From: [Downes, Scott G \(DFW\)](#)
To: [Ed Sewall](#); [Jeremiah Cromie](#)
Cc: [Ian Loveless](#)
Subject: RE: Ski Acres Estates
Date: Thursday, June 9, 2022 2:37:59 PM

Subject: RE: Ski Acres Estates

Jeremiah and Scott, here are the revisions to the mitigation plan we discussed in the field. I will be also be applying for the HPA through Apps for the placement of the LWD in the channel as we discussed shortly using this plan.

MITIGATION SITE PLAN, NOTES, & DETAILS

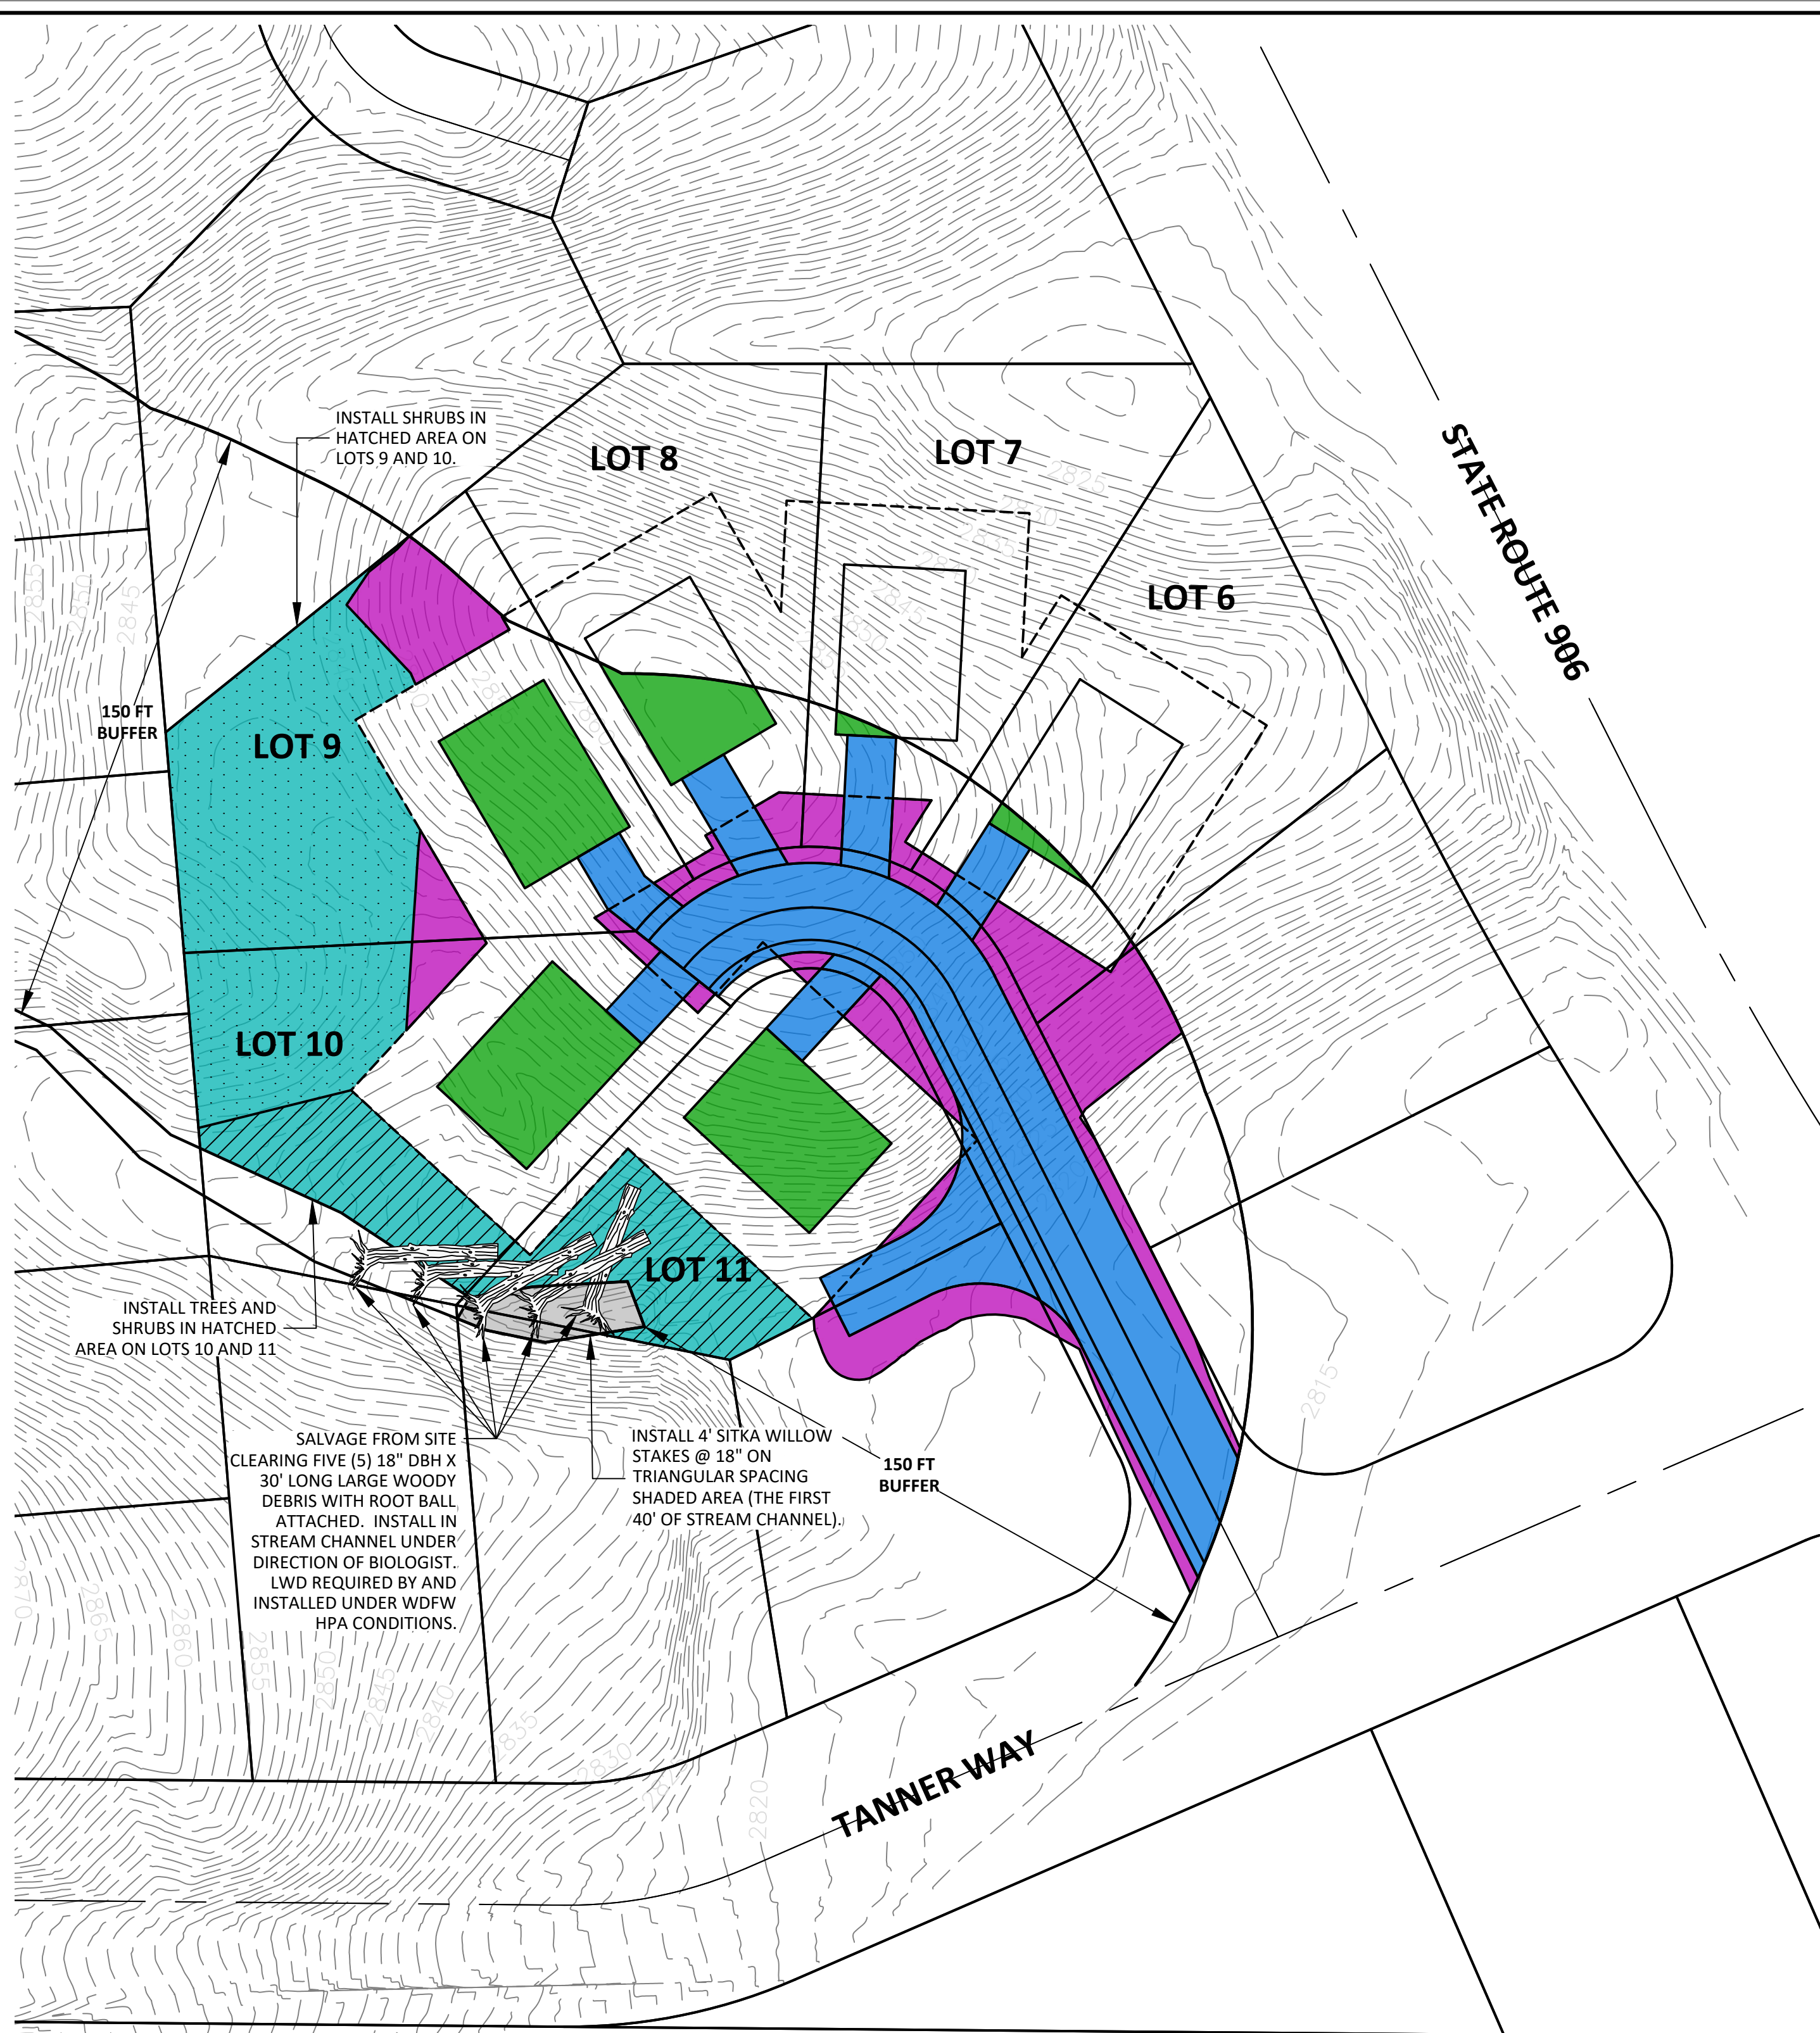
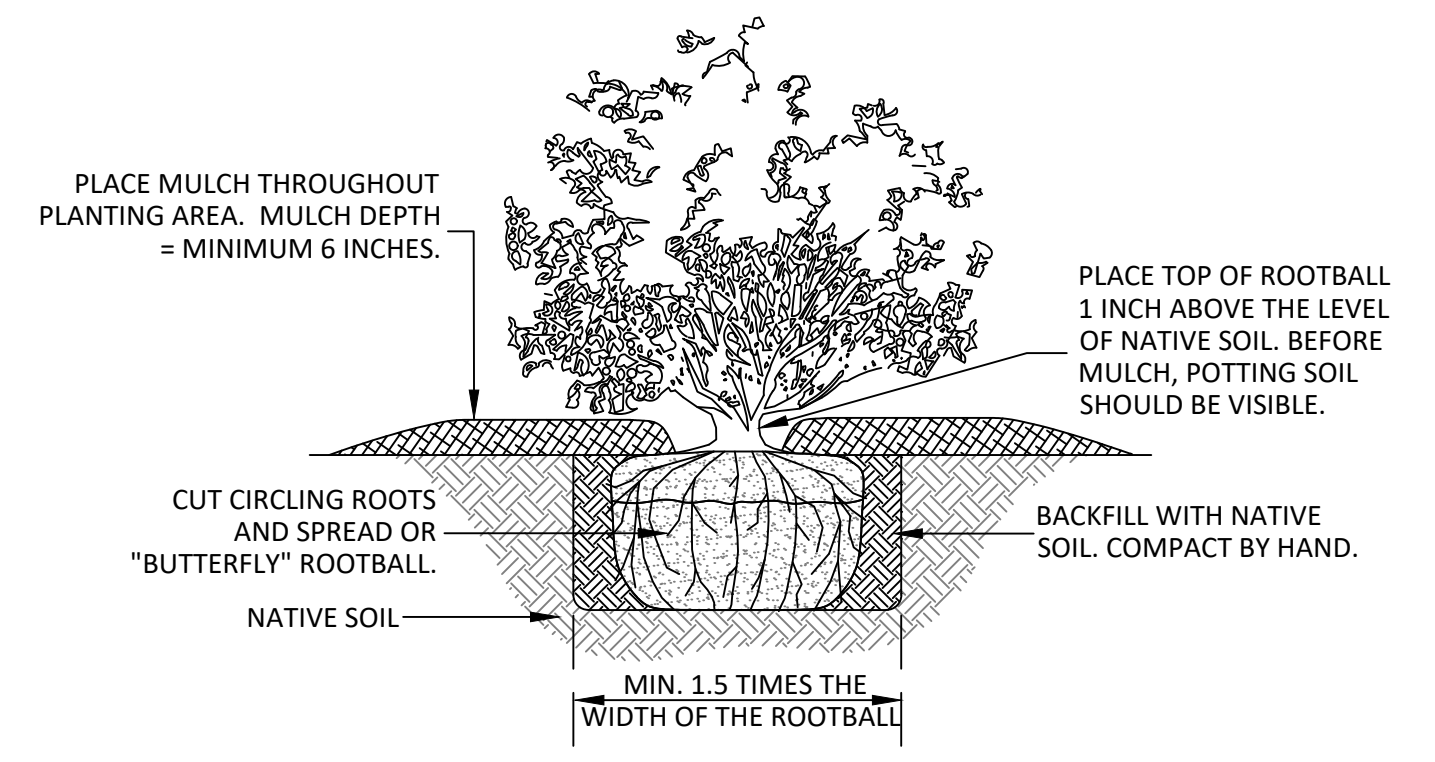
1. It looks like the stream enhancement area has lowered from the original 11,943 sq ft to now 9,560 sq ft. I'm guessing this is due to the clearing buffer around the homes you put in. On the creekside is there any way to shrink that a bit or is it already at the minimums for fire code?
2. On the logs, I was thinking more like 5-6. It looks like you have at least 5 at 18" diameter. Would you be willing to up the trees to 6 in the creek? Especially there appears to be a 20" and 36" fir to be removed in Lot 9 that would be great for the stream. This could help to offset the less sq ft in the enhancement area.
3. Just to tie things together, can you add a note that the trees will be placed under an HPA permit with WDFW?

Looks ok to me. If possible (schedules depending) I'd like to both be on site when trees are being placed and when the pre-construction meeting occurs with county on the planting plan.

Scott, here is the revised drawing with the changes requested.
Ed Sewall
